TELOPEA STAGE 1A

DPE RFI RESPONSE

13/12/2023

DPE RFI 6 NOVEMBER COMMENT

LOWER GROUND
SCALE: 1:500@A1

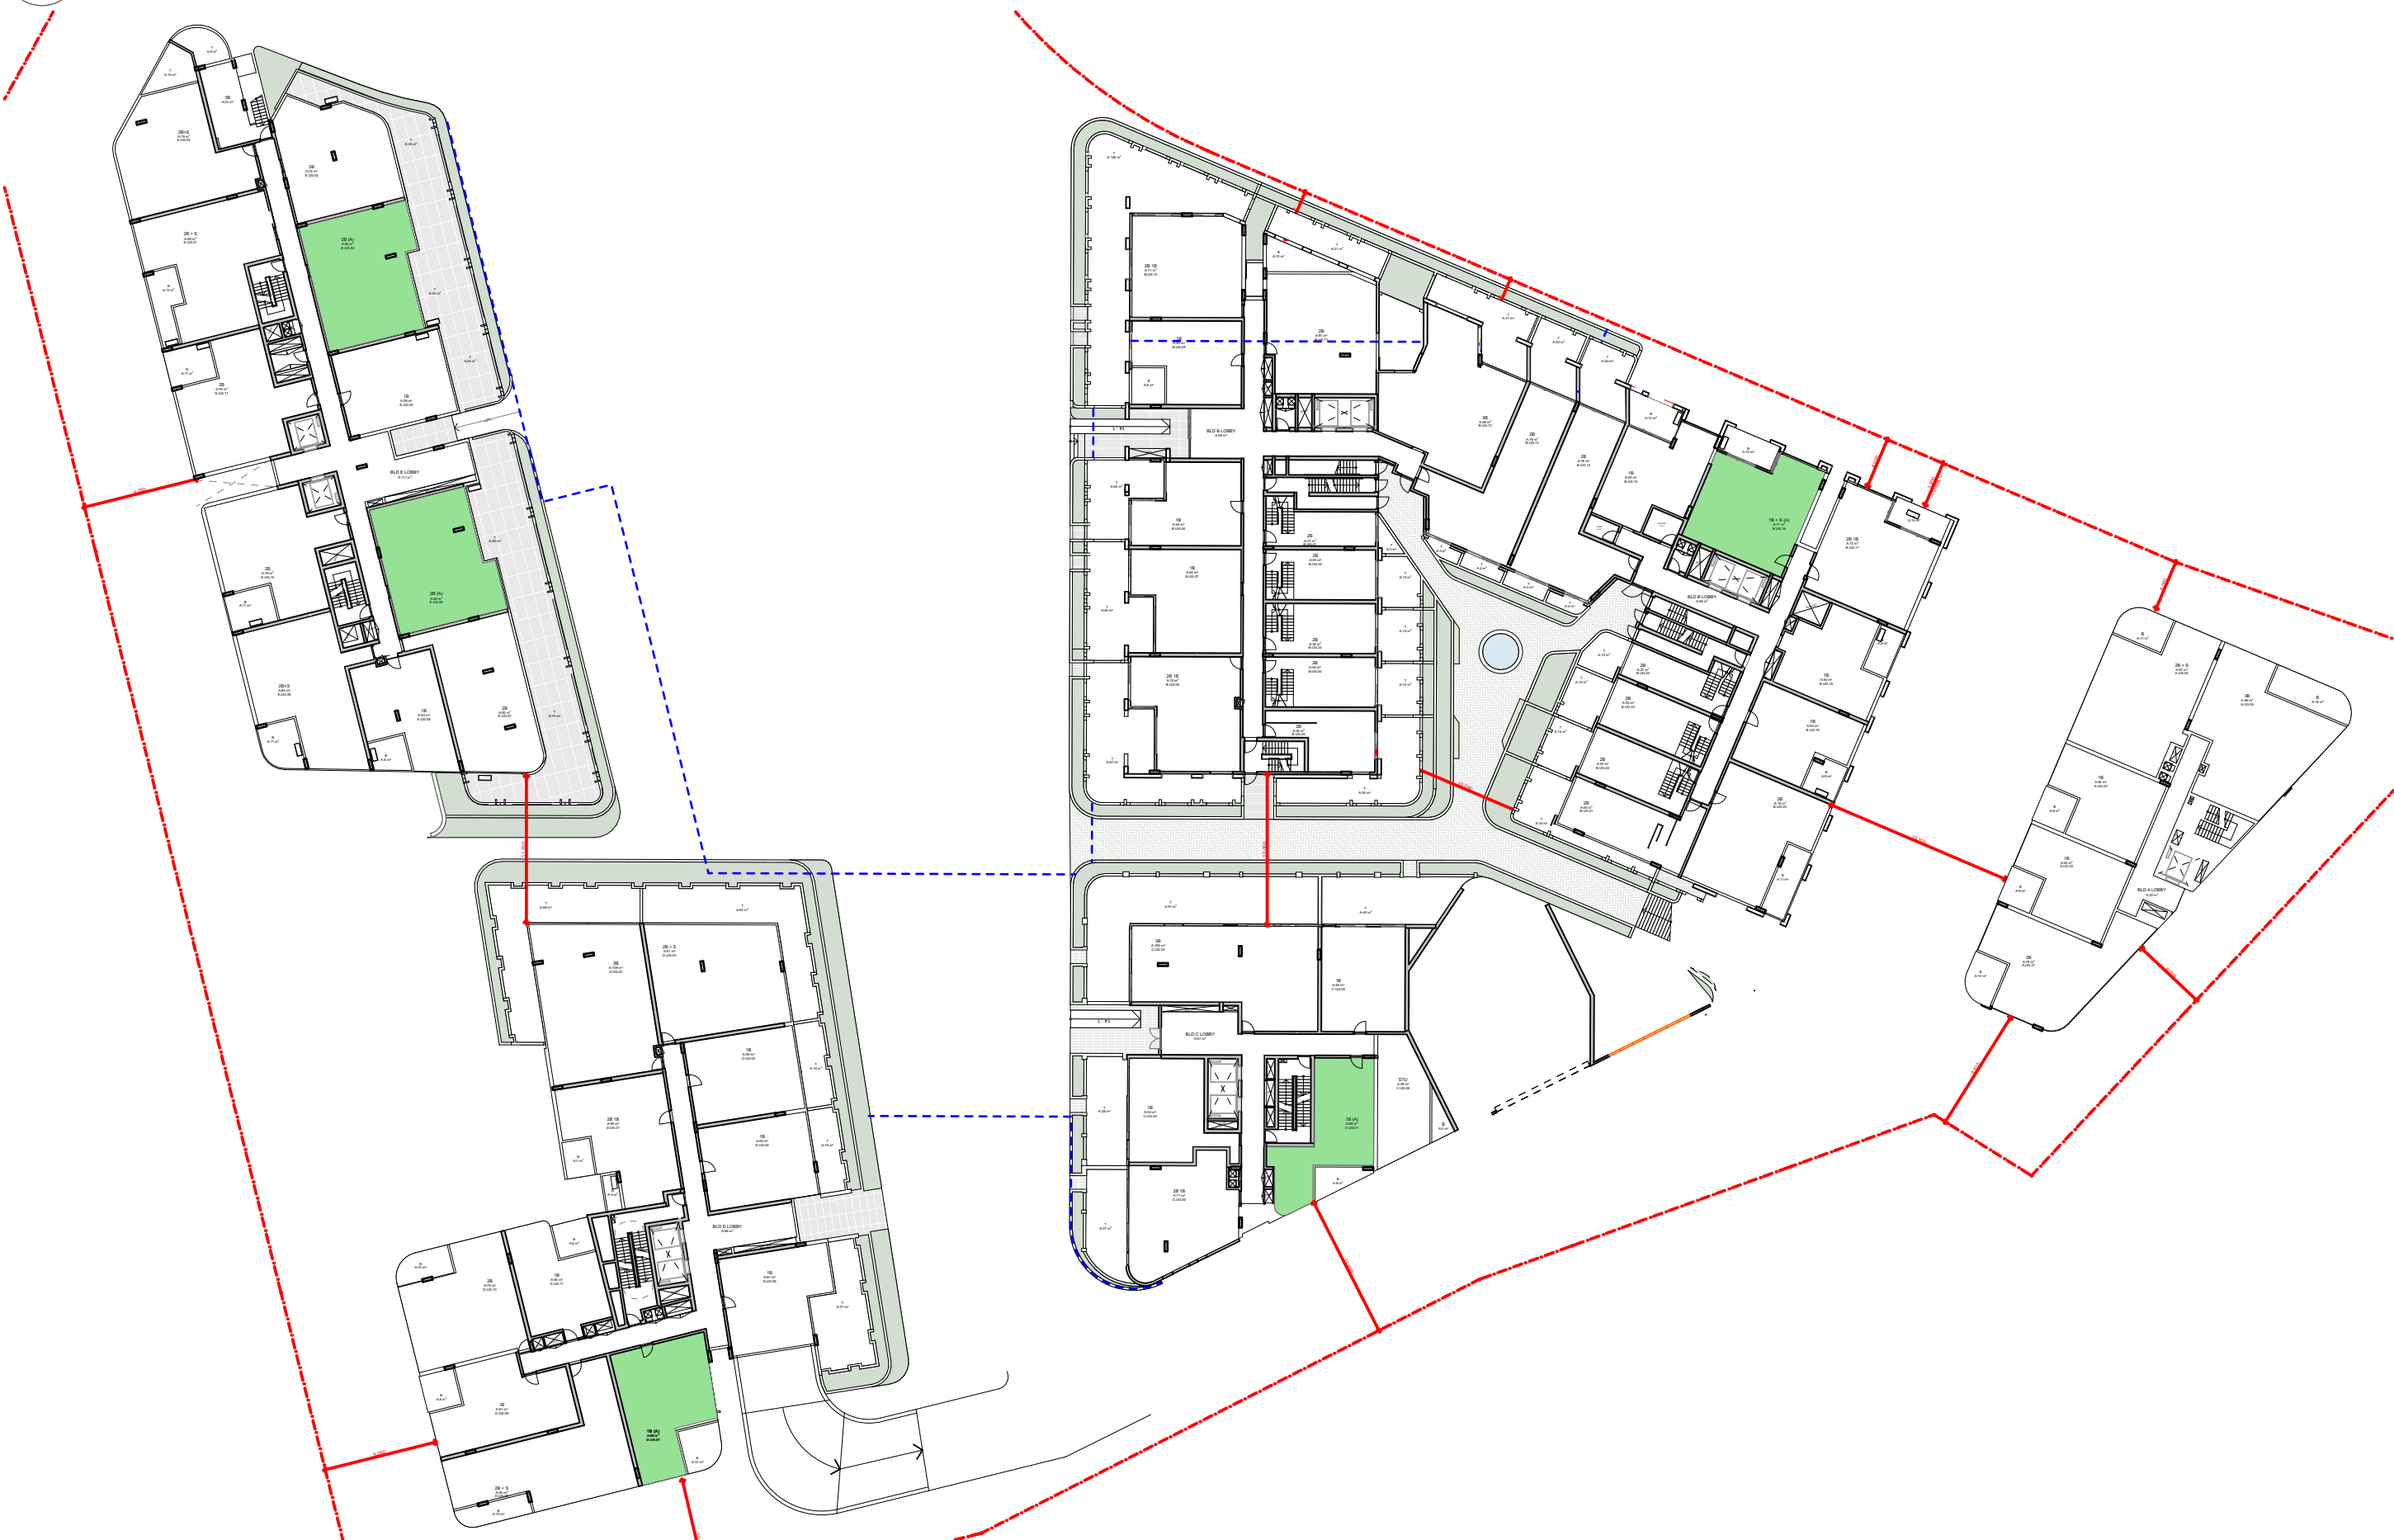
2.1.b.
The Department raises concerns about the proposed Building A and B basements projecting above the finished ground level along Sturt Street as it would result in large blank walls to the street. Amend the buildings’ design to ensure it achieves an appropriately designed interface to the street.

Amendments to Buildings A and B aim to reduce blank walls to the Sturt Street frontage and reflect Council's request for a minimum setback of 4 metres to be free of basement structure in order to establish thriving trees and landscaping. Specifically, to the Architectural Plans include:

Basement 02:
Relocation of 10 car spaces and storage spaces to provide a 4 metre setback along Sturt Street

Introduction on 1 x one bedroom apartment in Building A

Basement 01:
Relocation of 5 car spaces and storage spaces to provide a 4 metre setback along Sturt Street

Introduction on 1 x one bedroom apartment in Building B

Lower Ground:
Reconfiguration of B.LG.01, B.LG.02 and B.LG.03 to provide terraced landscaping
